Welwyn Hatfield Borough Council  
Planning Department  
Council Offices  
The Campus  
Welwyn Garden City  
AL8 6AE

**Ref: 6/2022/2801/MAJ**

Thank you for consulting us on the submitted planning application for Campus East Car Park, College Way, Welwyn Garden City, AL8 6DG. Demolition of all existing buildings and structures followed by the erection of five buildings to provide 313 residential units (Use Class C3); car and cycle parking, cycle and refuse storage, hard and soft landscaping, external lighting, drainage, infrastructure and all associated works.

Title
FLAT BLOCKS C & D
LEVELS 0, 1, 2 & ROOF
AFFORDABLE

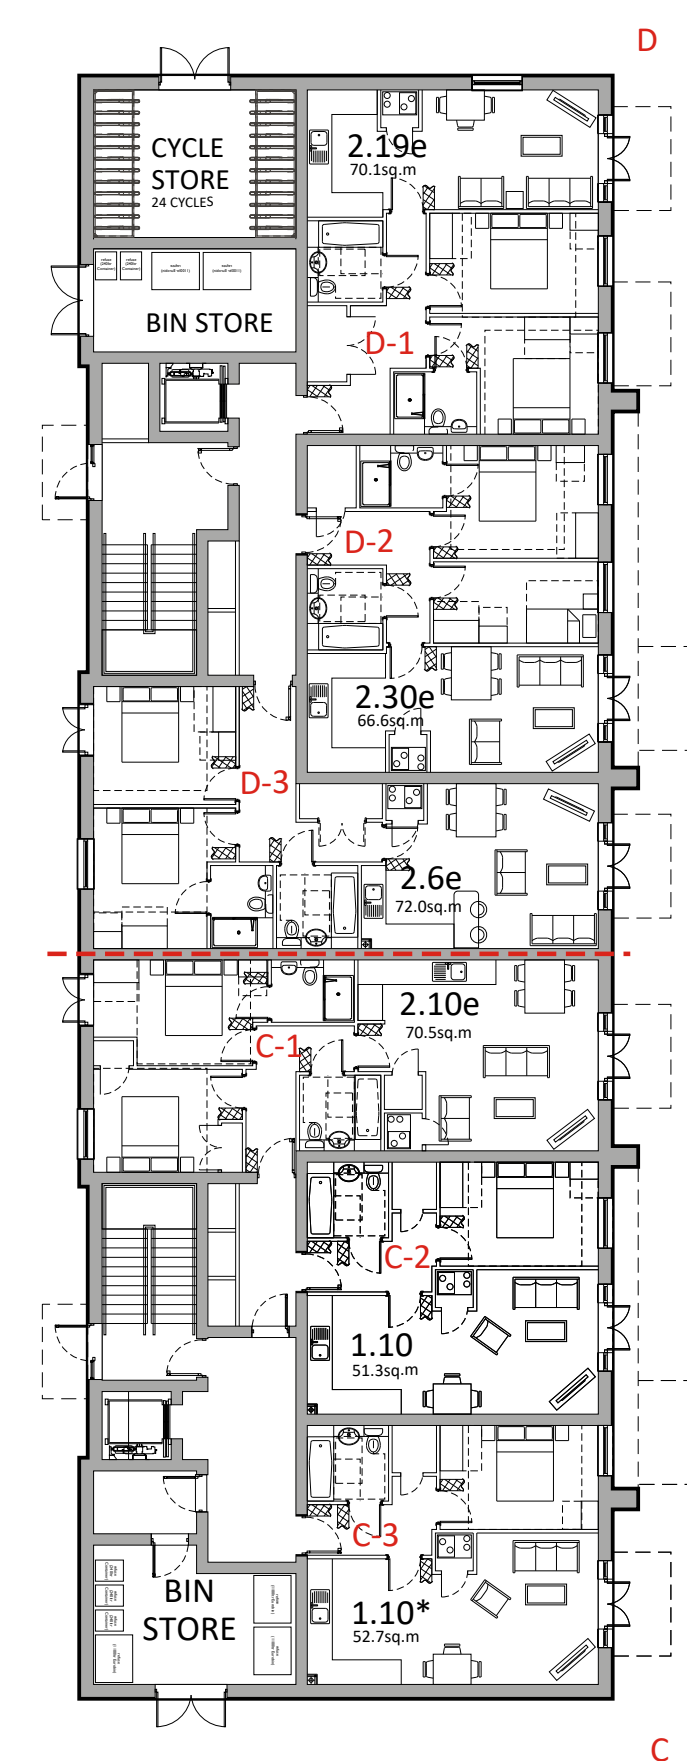
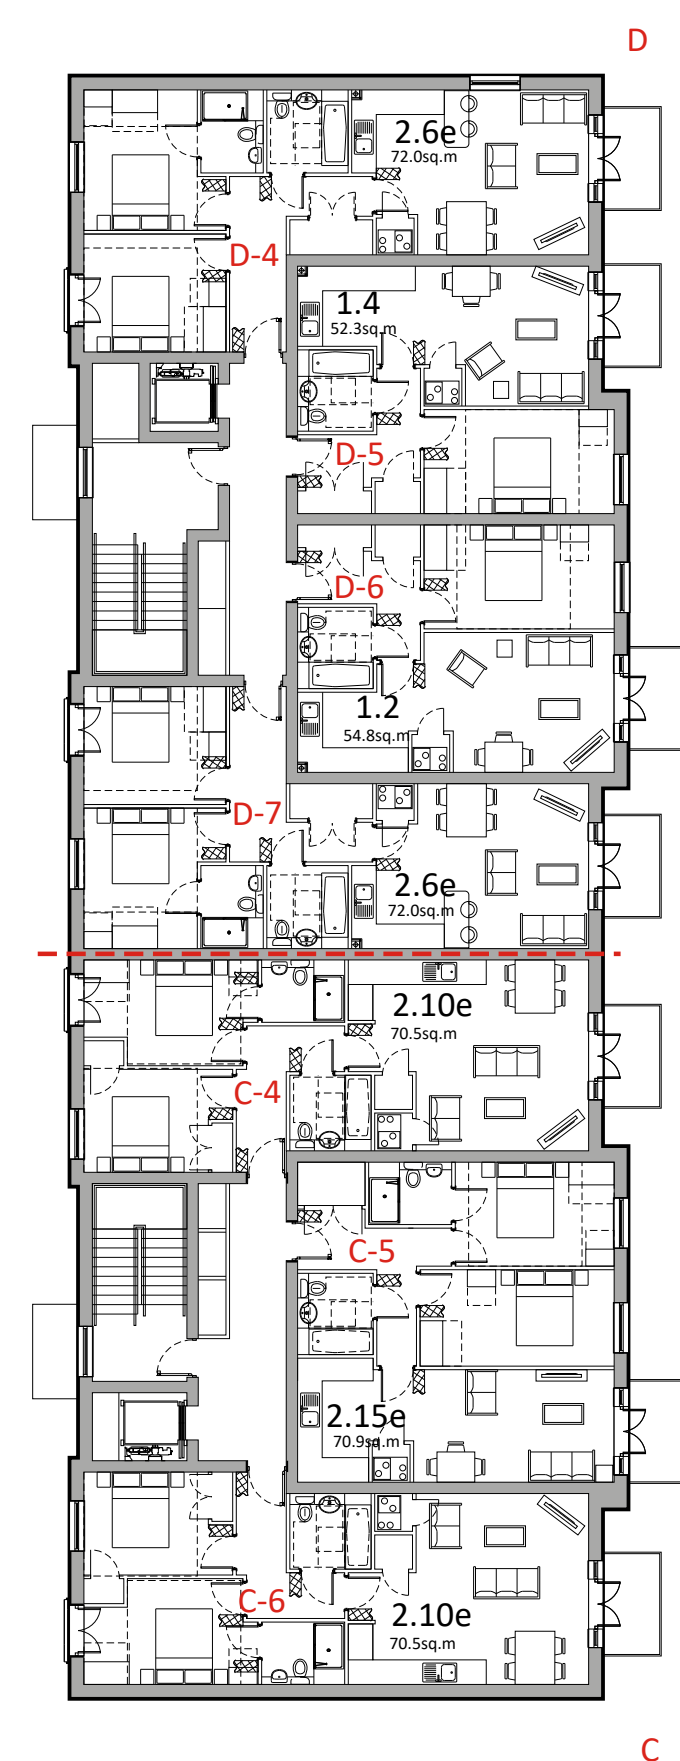
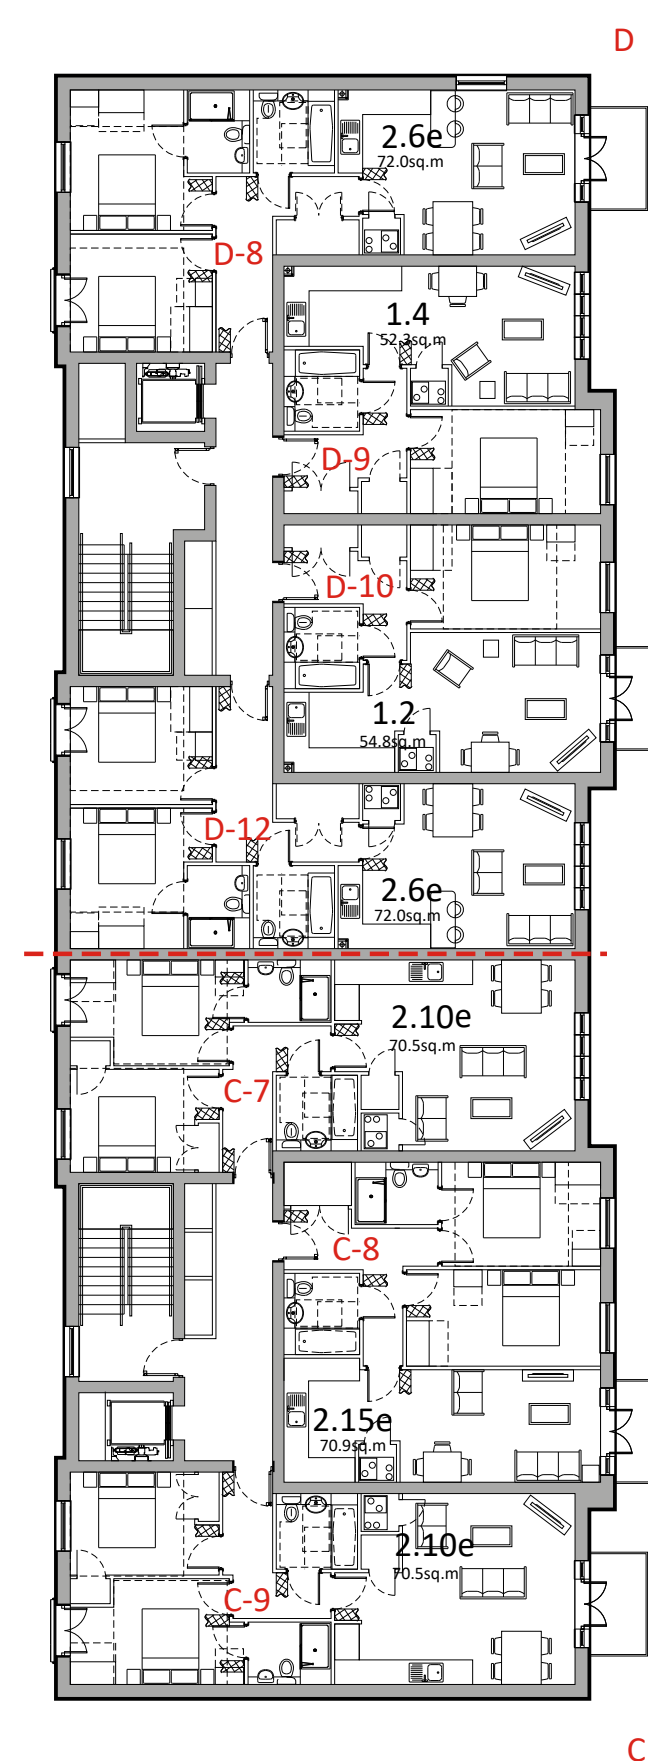
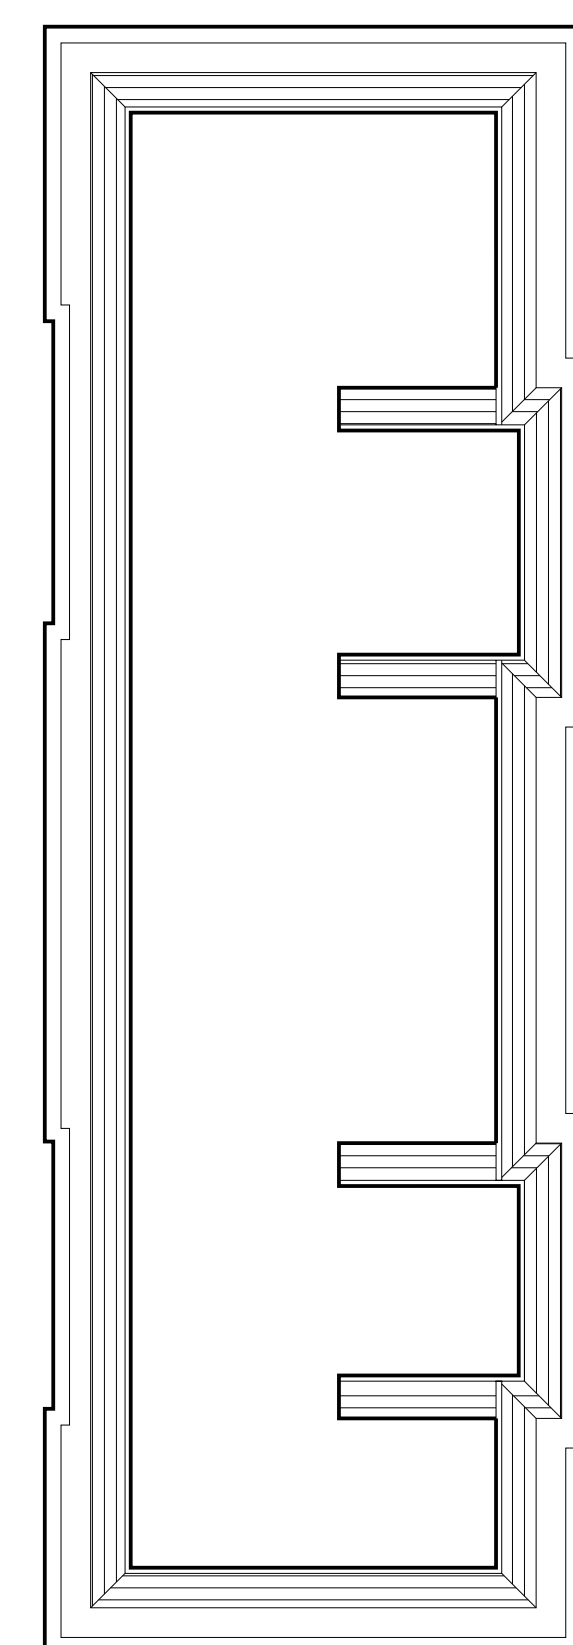
- Rear elevation of Blocks D and C could be improved, especially considering the relationship with the adjacent residential areas. The balance of fenestration pattern and solid to void seem muddled, lacking the design approach highlighted in the DAS (page 38).
